Ref: Planning Application M/10/15/HH for Side & Rear Extension to 37 Lane End Road.

Section 6 of Party Wall Act 1996 ('The Act')

PROPOSED GROUND FLOOR PLAN 1/50

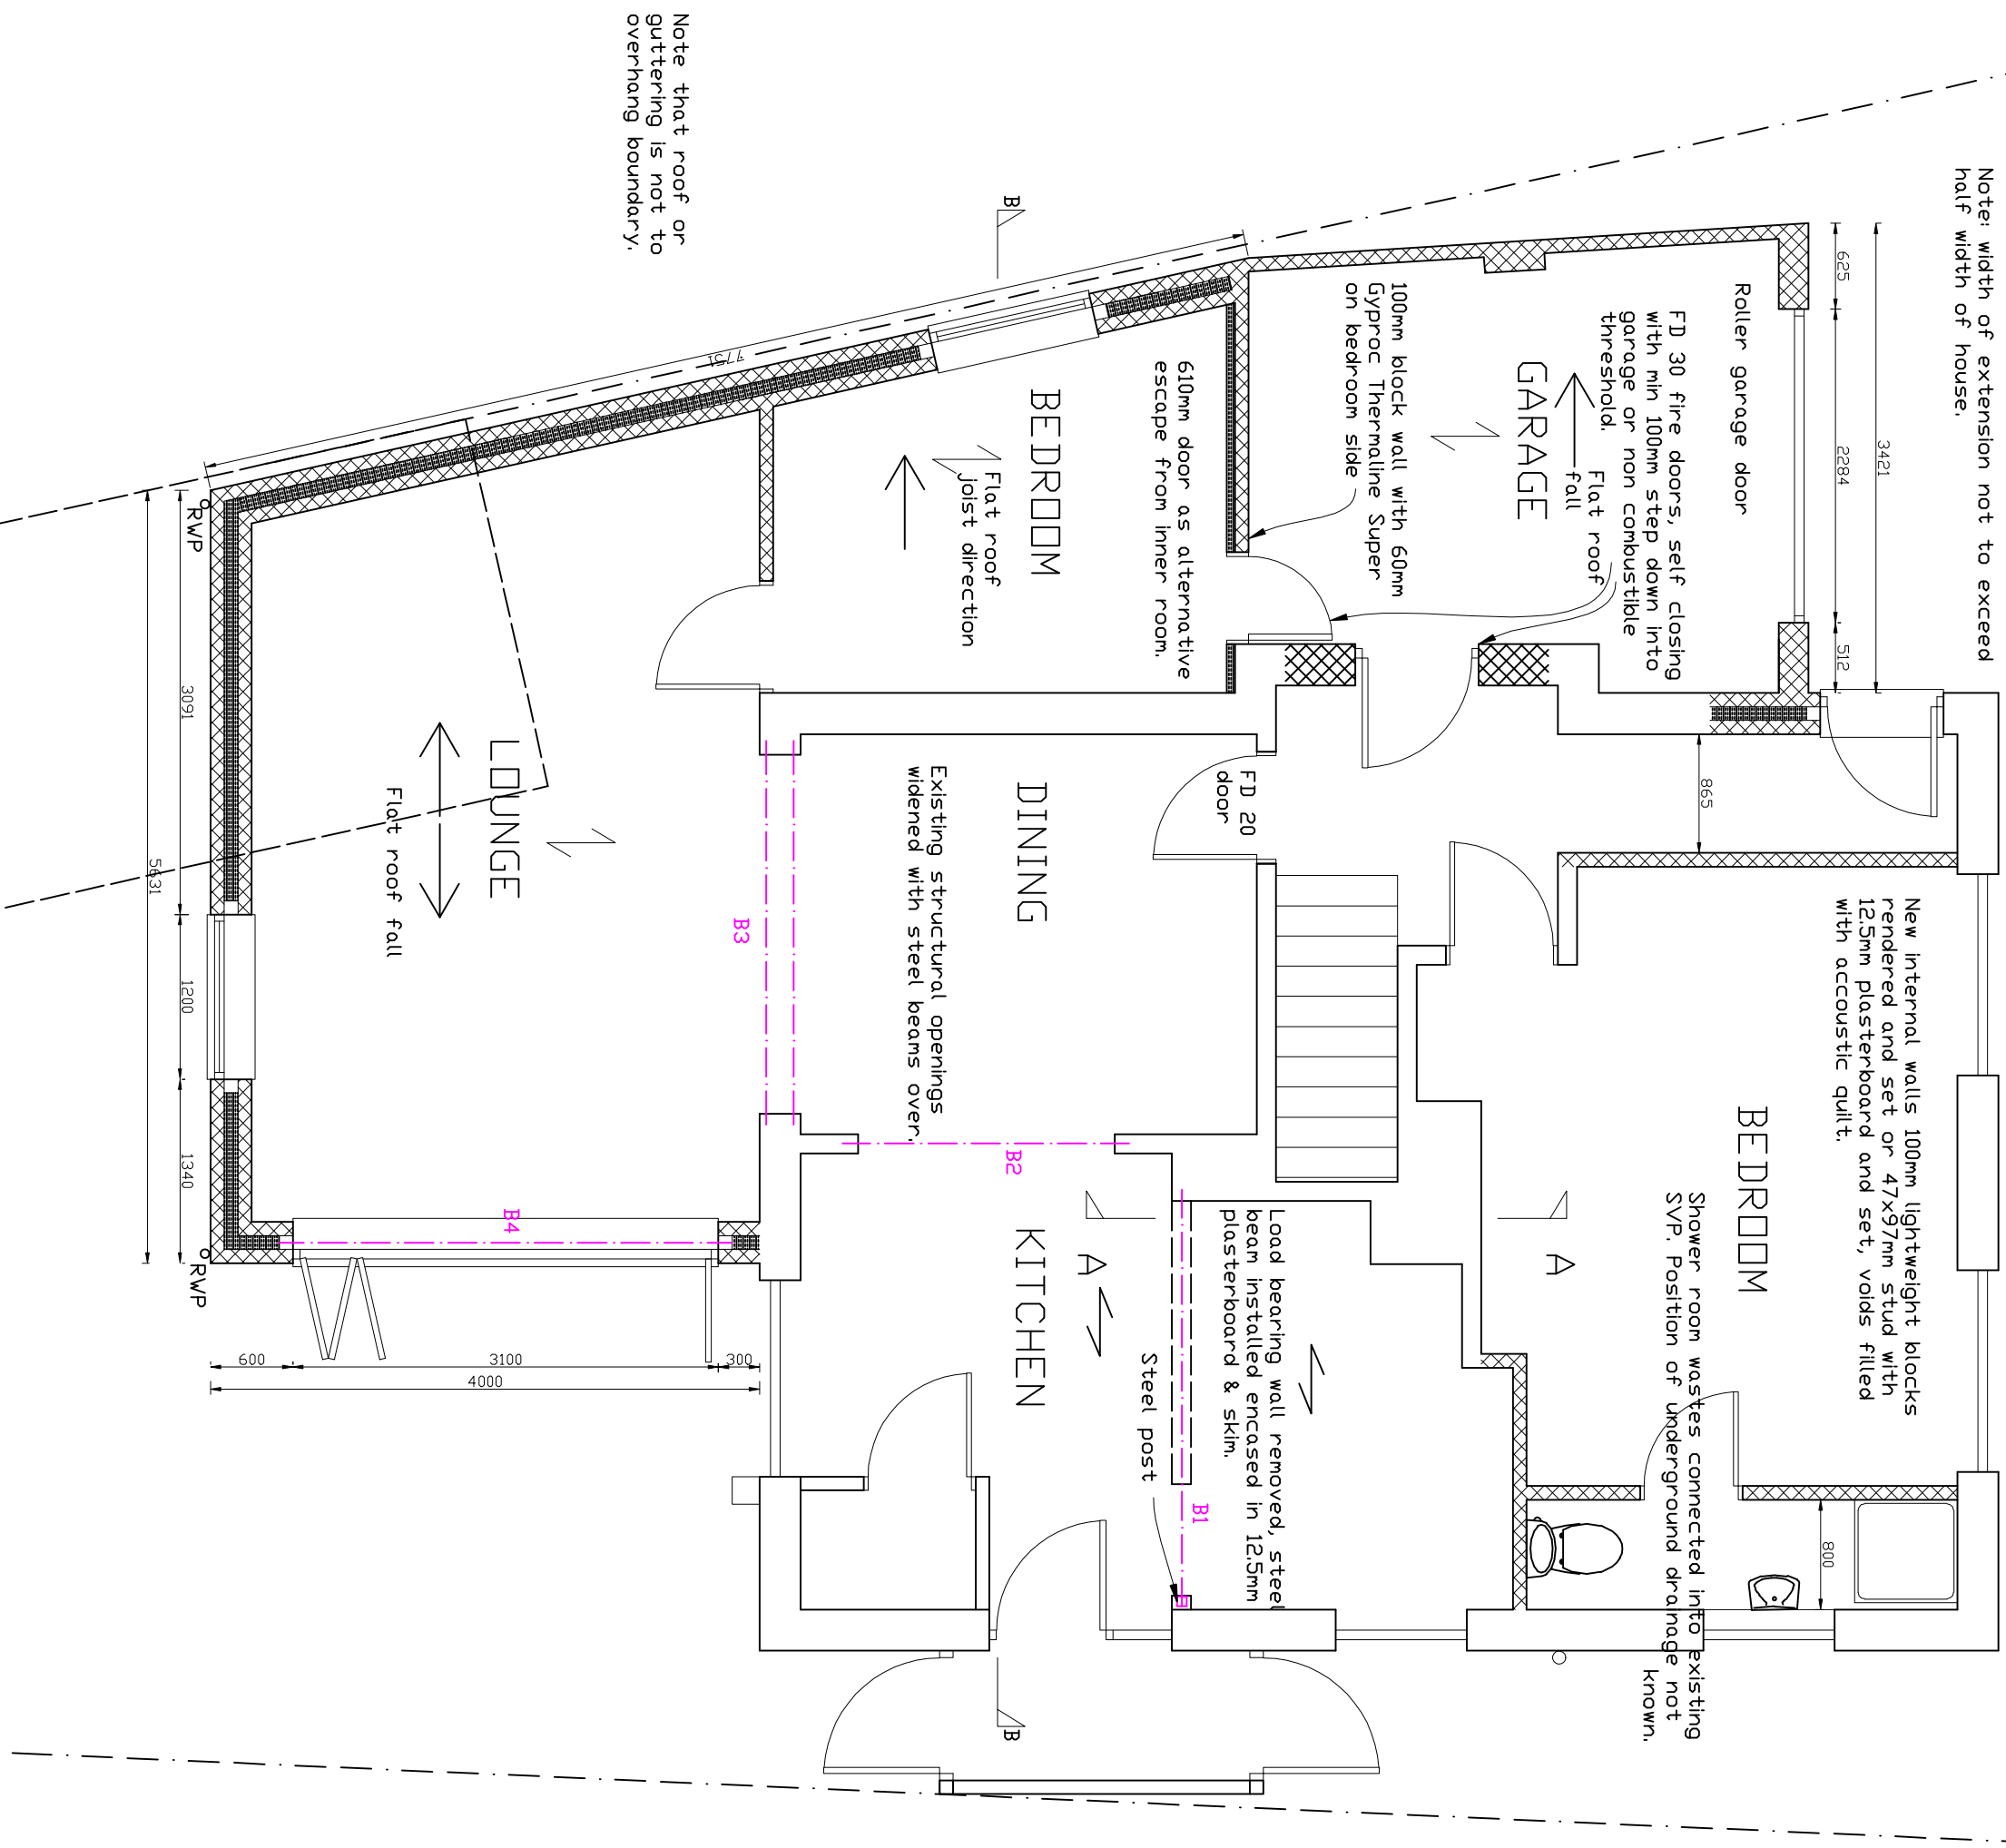
- The proposed wall of the extension would be only 44inches (1112cm) from my front door, it is 40inches to the centre of the chain link fence which divides our properties.

- Party Wall etc. Act 1996 Section 6 As the proposed extension is well within 3 metres of my property I very concerned that the excavations / foundations may cause significant harm to my property as the proposed foundations will be well below my level of my foundations as per Diagram 6 of paragraph 28 of the Act.

PROPOSED SOUTH EAST ELEVATION 1/100

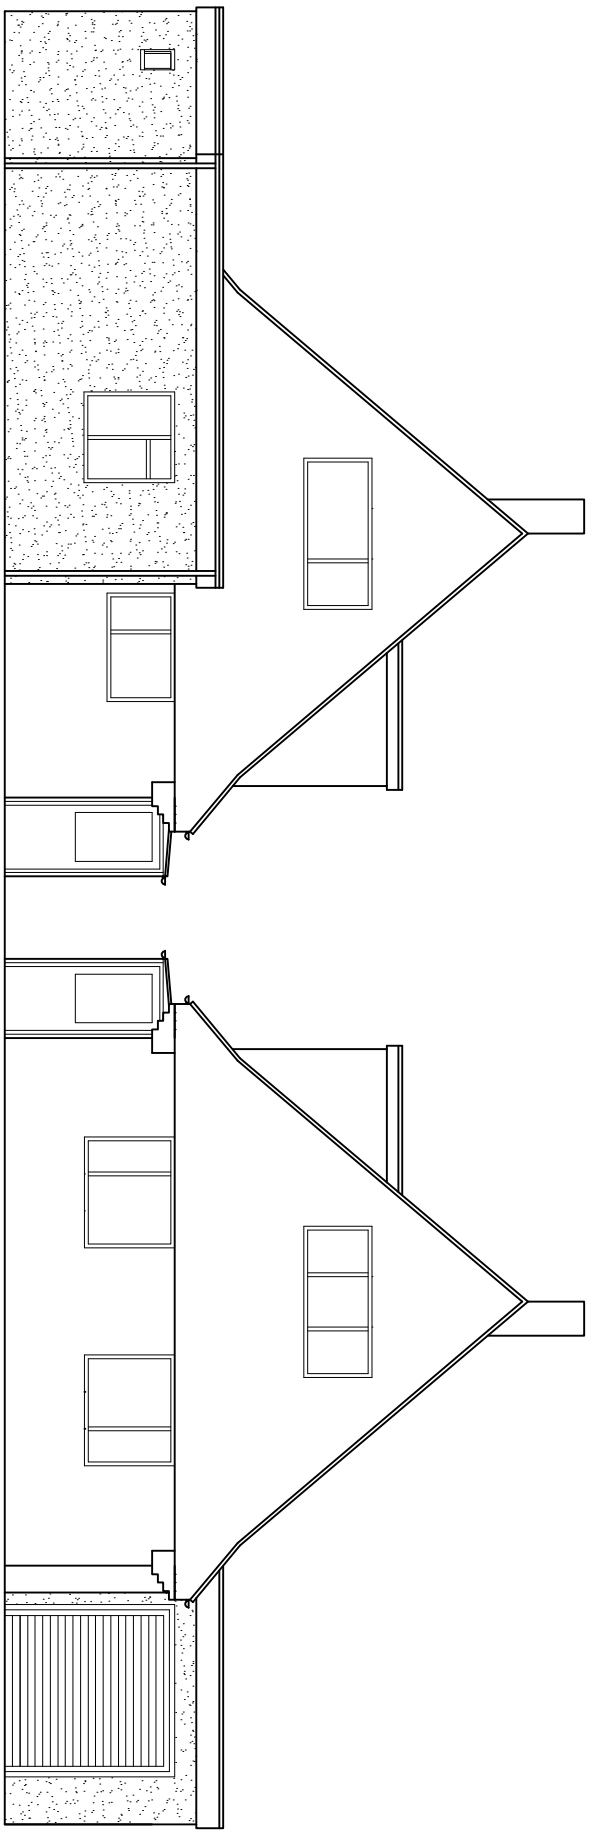
- Material Consideration The proposed height of 3 metres takes the extension well above the height of my guttering and would therefore significantly reduce the amount of natural light through my front door, I had my front door changed some years ago to one that has large glass panels to maximise the amount of natural light into my small hallway, this was done as both my wife and I are disabled and have difficulties with the very basic activity of walking and that means we need to have as much light as possible in our hallway for our own safety.

- We face the same issues with the small bedroom which will loose a significant amount of natural light, making it necessary to switch the light on, which we do not need to do at the moment.
